Appeal Decision

Appeal Ref: APP/T2350/D/13/2199040

Slimrow, Slaidburn Road, Newton in Bowland, Clitheroe, BB7 3DL

- The appeal is made under section 78 of the Town and Country Planning Act 1990 against a refusal to grant planning permission.
 - The appeal is made by Mr & Mrs Bamford against the decision of Ribble Valley Borough Council.
 - The application Ref 3/2013/0321, dated 18 March 2013, was refused by notice dated 20 May 2013.
 - The development proposed is construction of single storey side extension to provide improved living and bedroom space.
-

Drawing Title
PROPOSED PLAN & ELEVATIONS

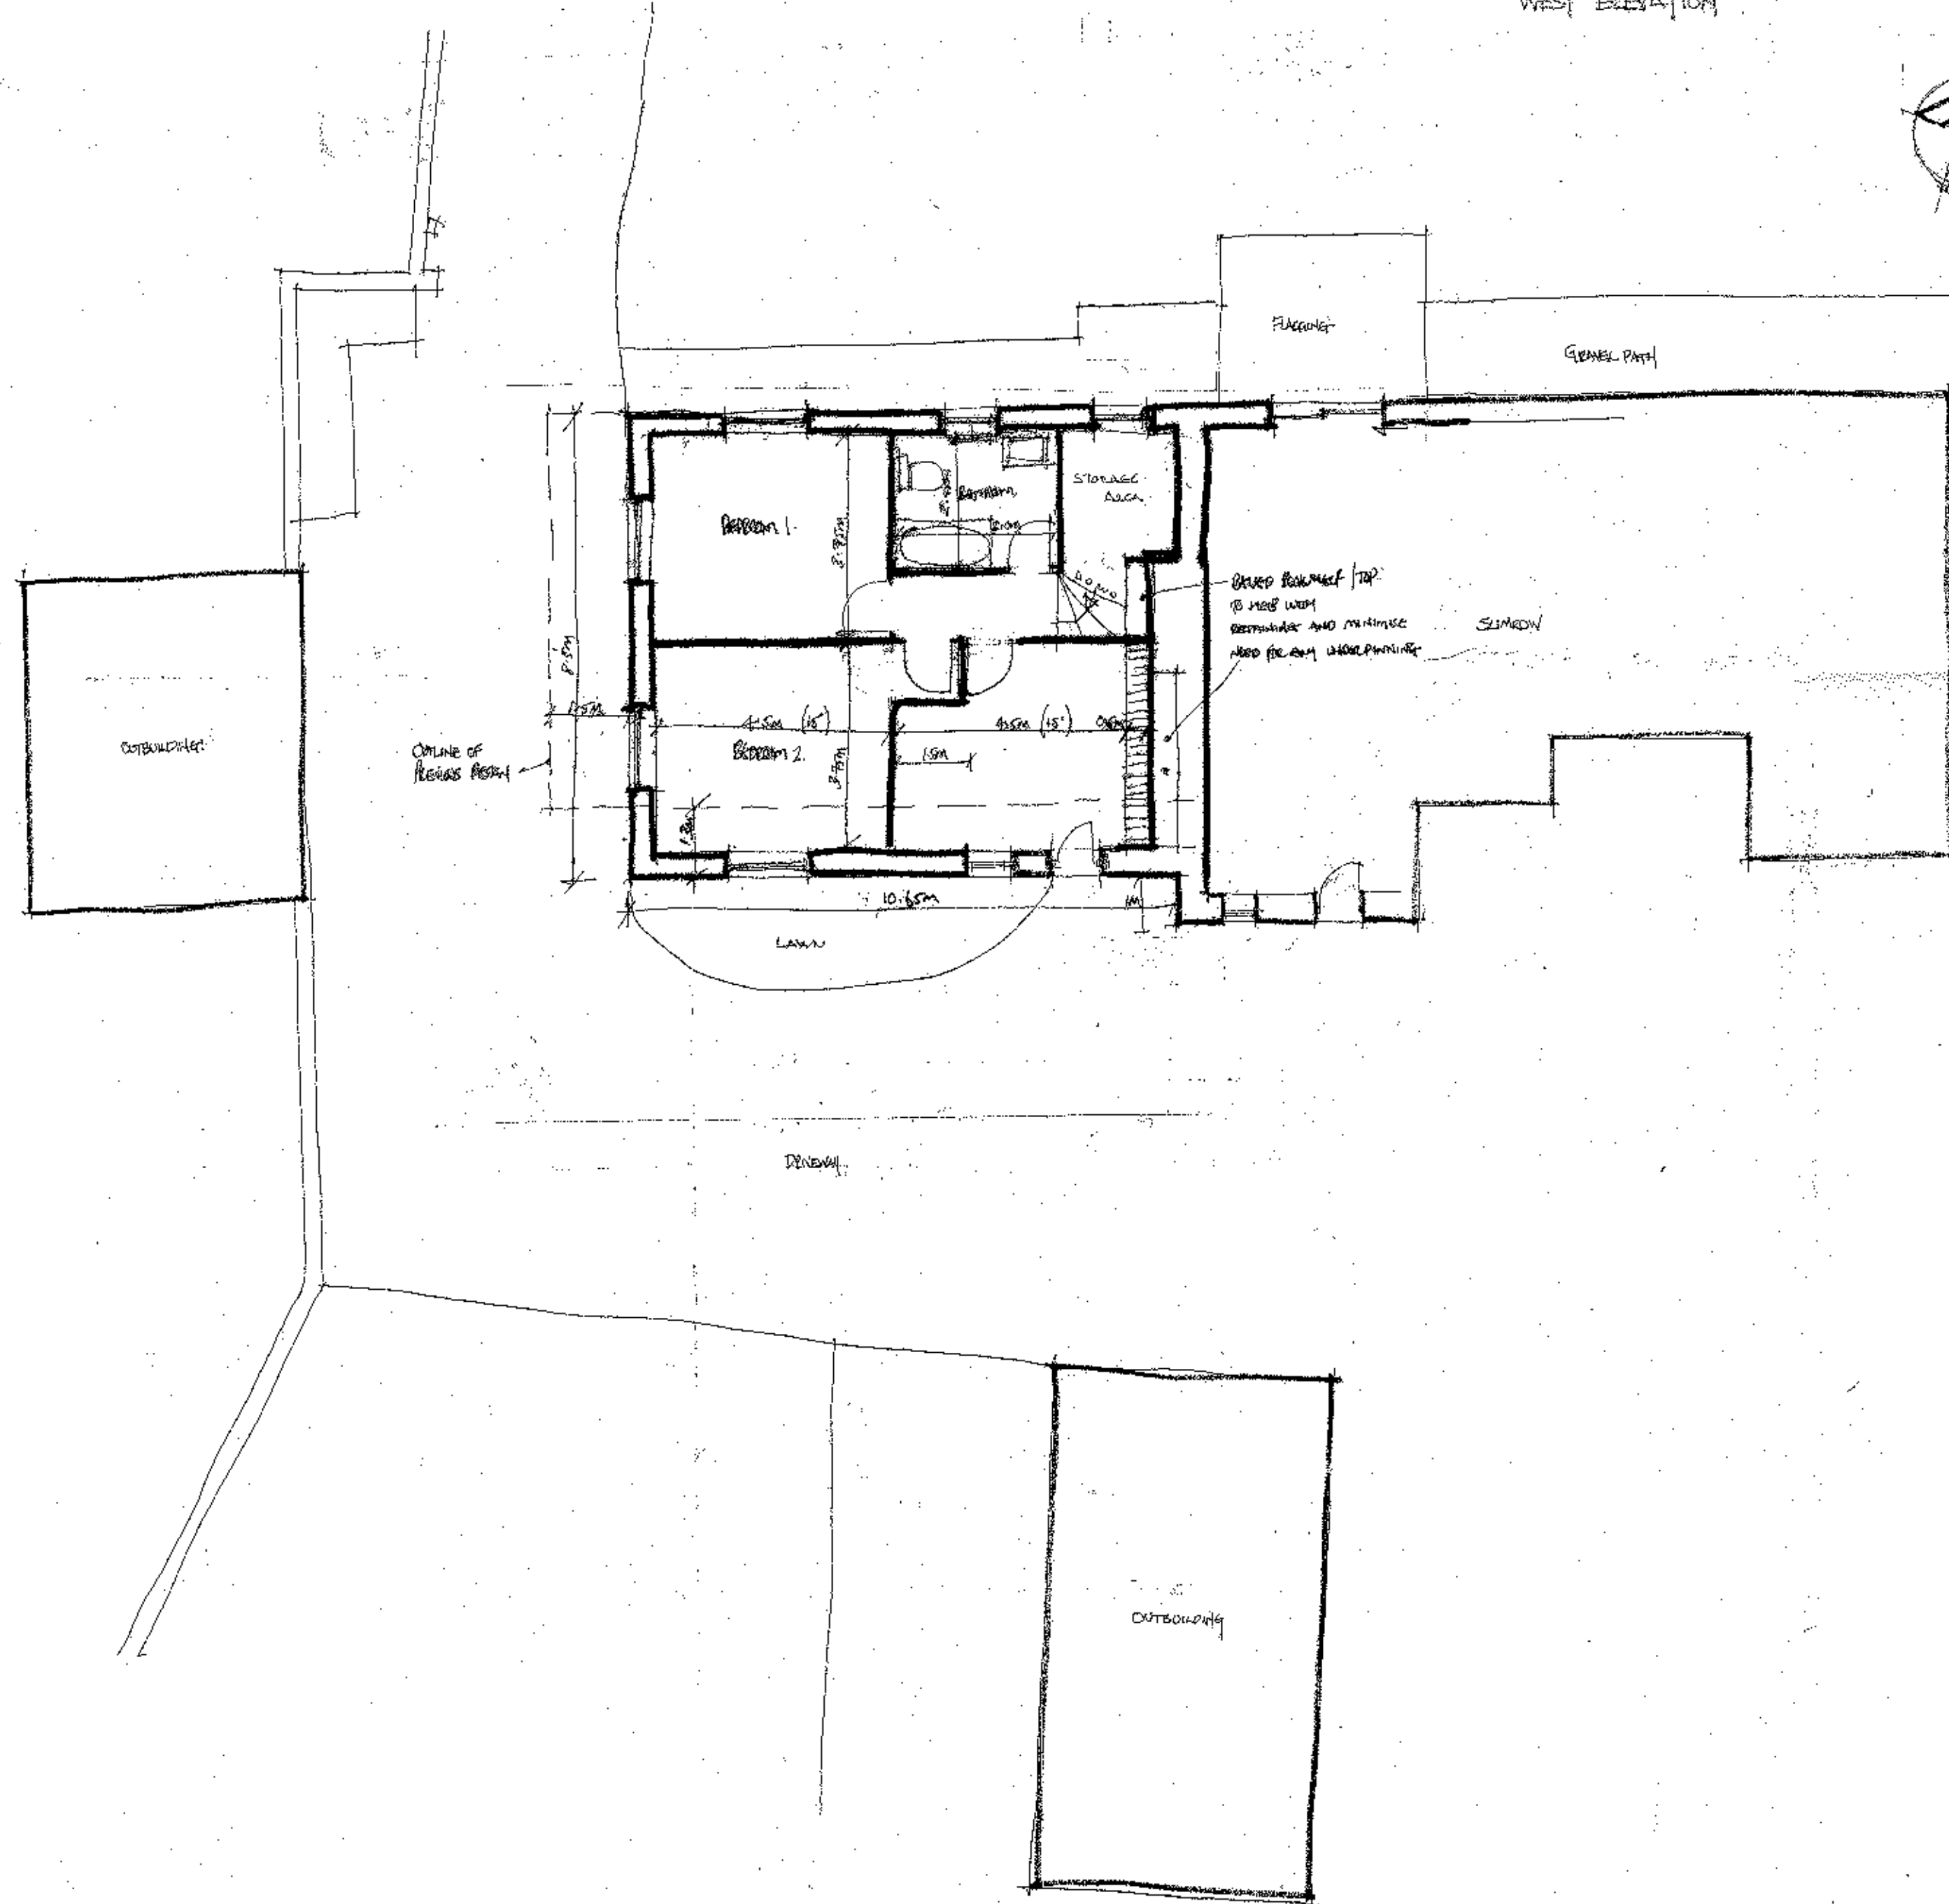
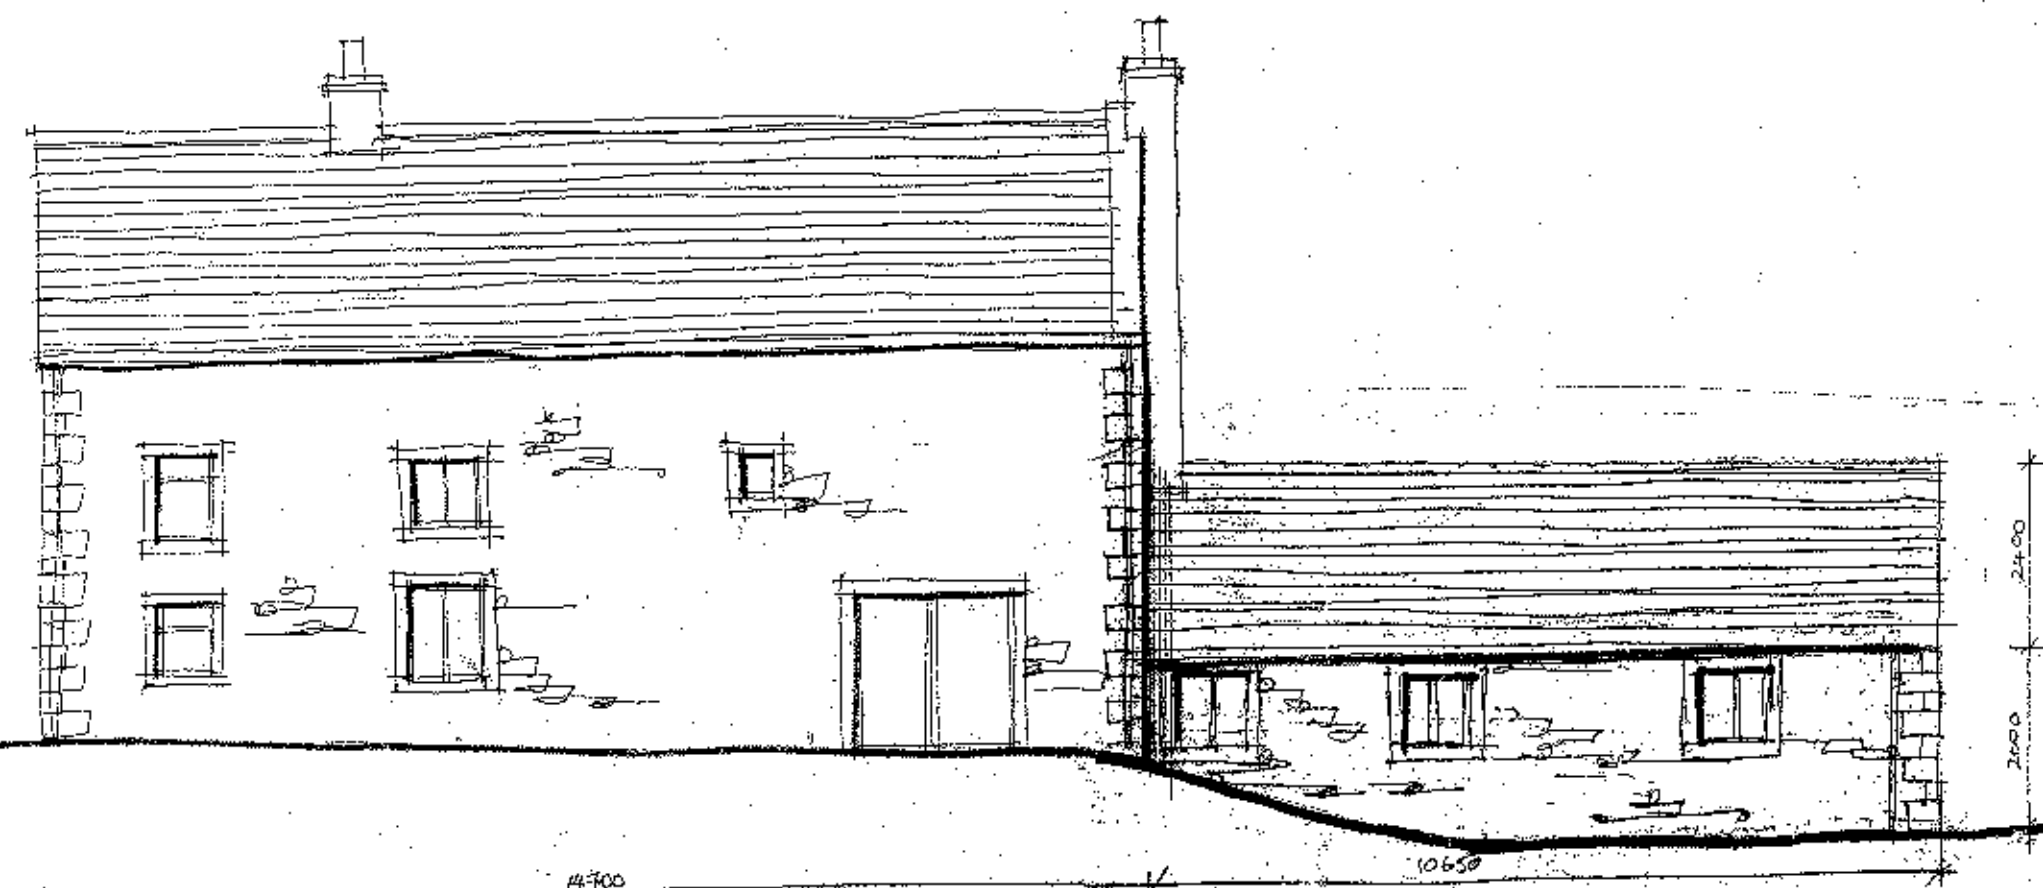
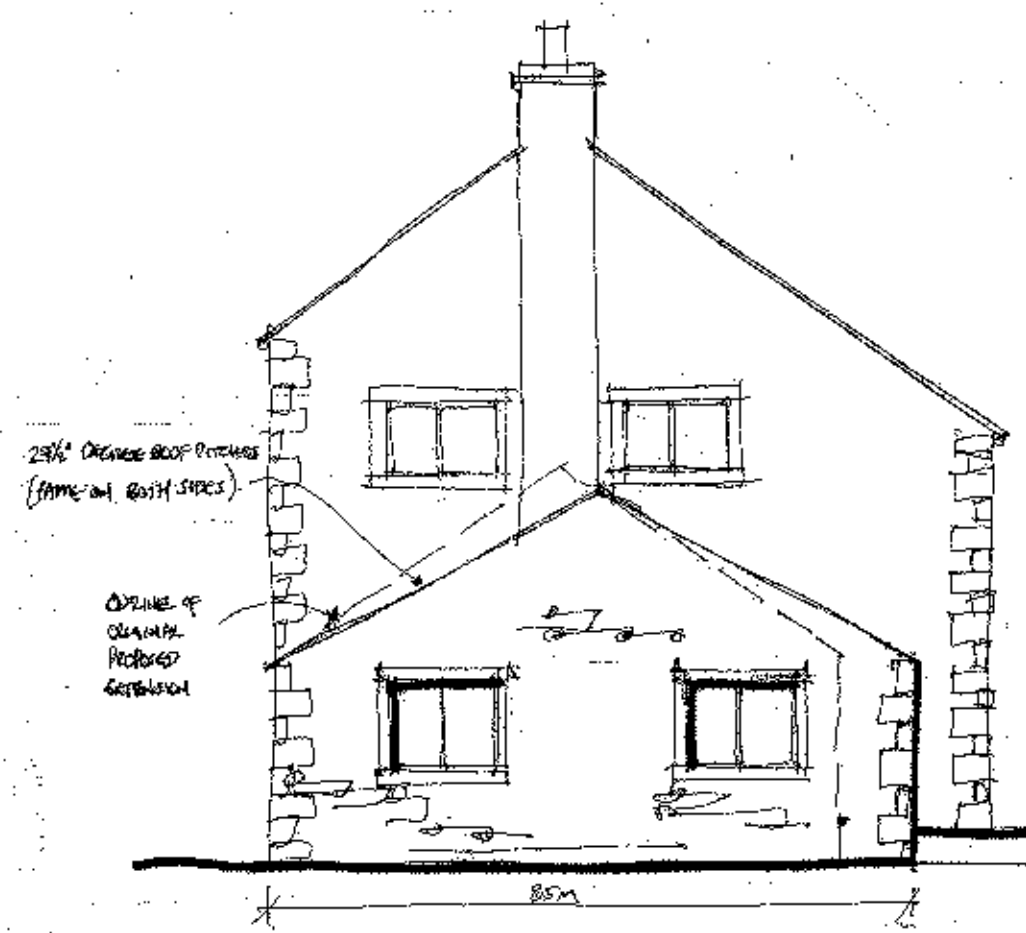
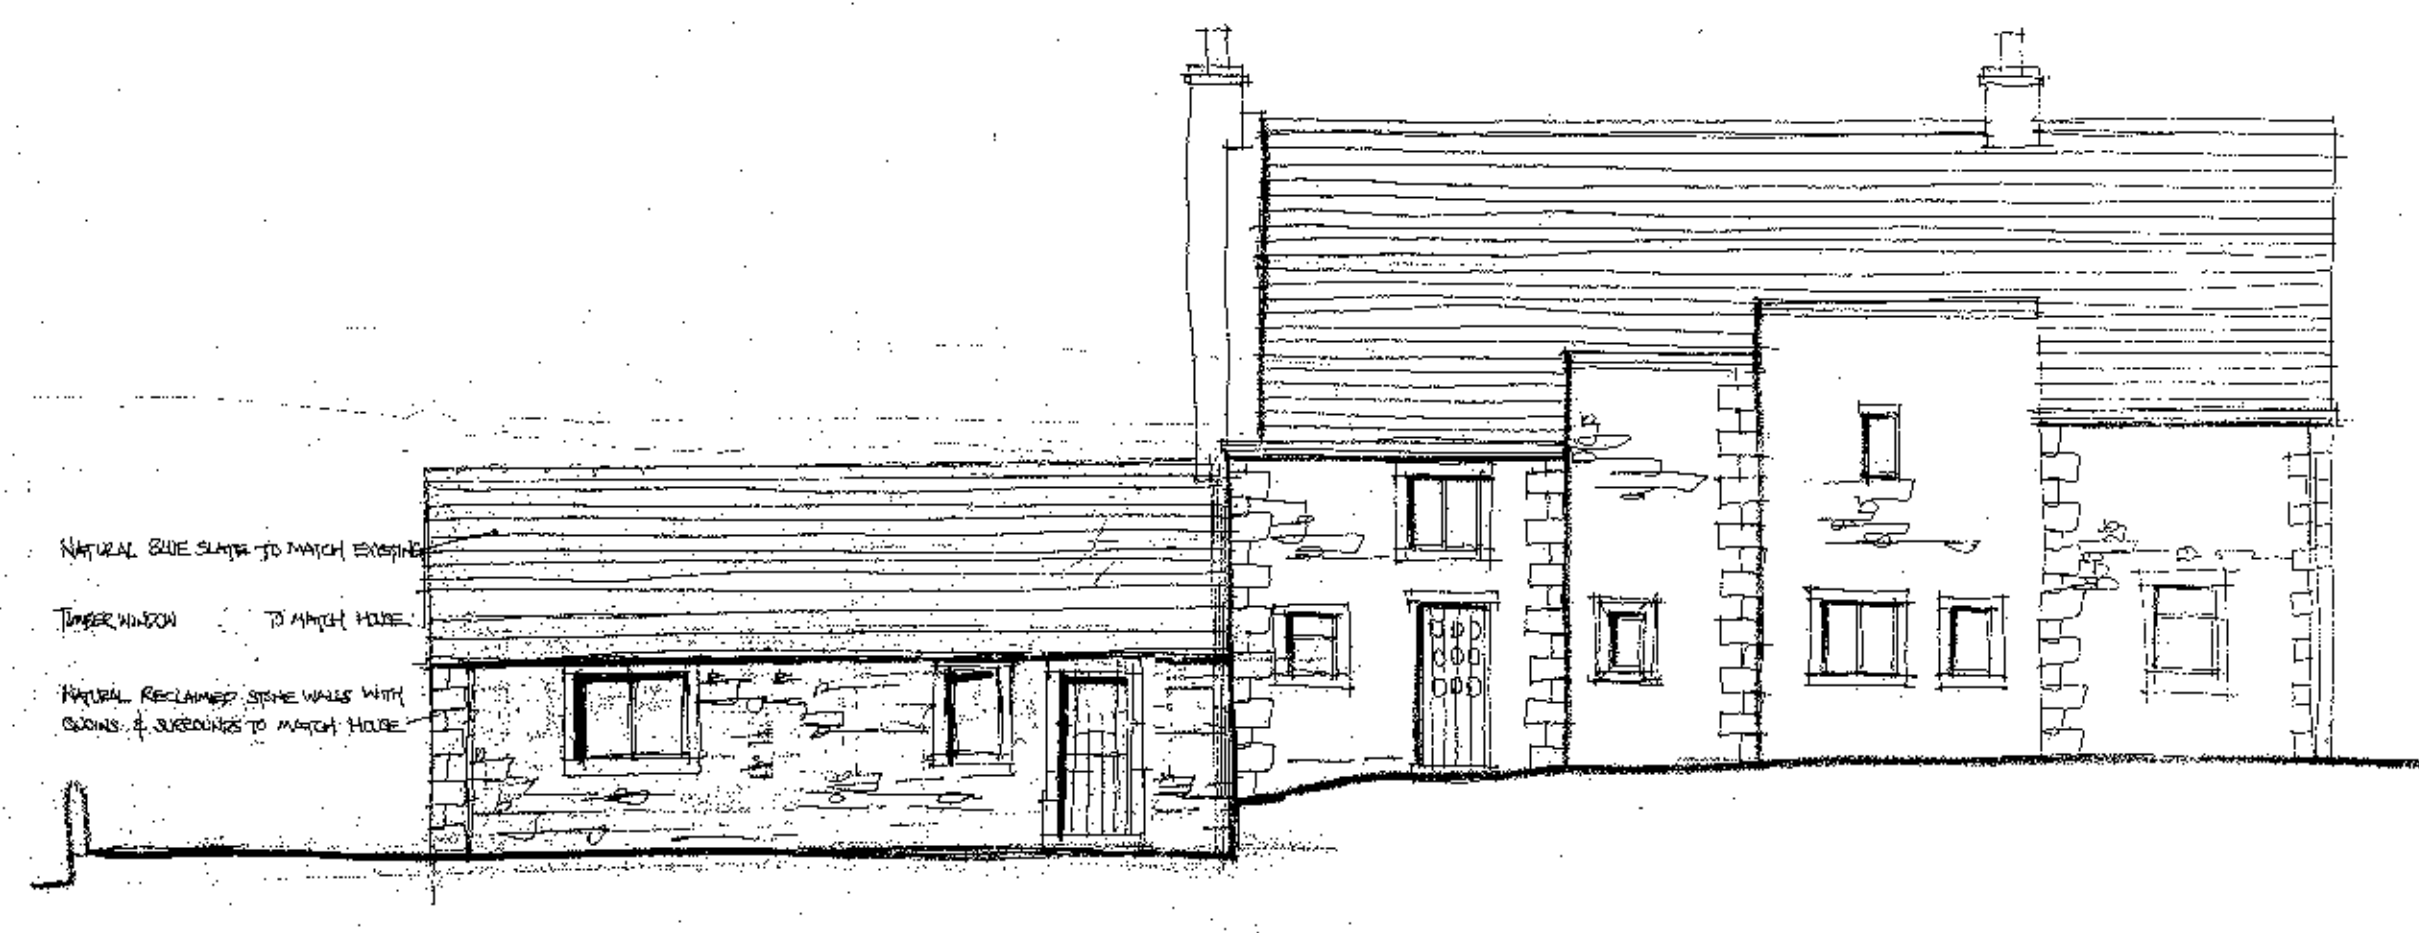
7. The property is adjoined to one side by a level grassed area and it is here that the single storey extension is proposed. It would cover a substantial footprint of around 10.6 metres long and 8.5 metres deep which would significantly extend the footprint of the existing property. Despite being relatively low, the length and depth of the proposal would lead to an extension of considerable mass which would compete in scale with the main dwelling. The resulting roof would also have a relatively shallow pitch which would be inconsistent with that on the main dwelling and this along with the number of windows required to serve a domestic addition of the scale proposed would emphasise the depth of the proposal. As a result of its disproportionate size the extension would appear incongruous and suburban in form, and would be at odds with the traditional form of the rest of the building.

8. The property is not visible from the road and due to the lie of the land and the drystone wall that surrounds the rear of the site only the upper floor of the property is apparent in the wider landscape. Nevertheless, the proposal would sit immediately adjacent to the public footpath which crosses the property and would be prominent in views from it. Whilst I note that the appellant considers the footpath not to be well used, it does nonetheless provide a public view of the site from which the visual impact of the proposal would be evident, and this adds to the harm identified above. Therefore, notwithstanding the limited views of the proposal in the wider landscape, it would fail to conserve or enhance the landscape and character of the Forest of Bowland AONB.

which would echo the form of an agricultural building and restore the unity of the original farm complex. For the reasons outlined above, the form of the building proposed would not provide any visual benefit. I also note the appellant's reference to guidance within the SPG in relation to the scale of domestic additions. These guidelines are not intended to be prescriptive and in any case do not alter the visual harm the proposal would give rise to. Finally, I also note that the proposal would provide additional accommodation for the appellant, but this benefit would not outweigh the harm identified above.
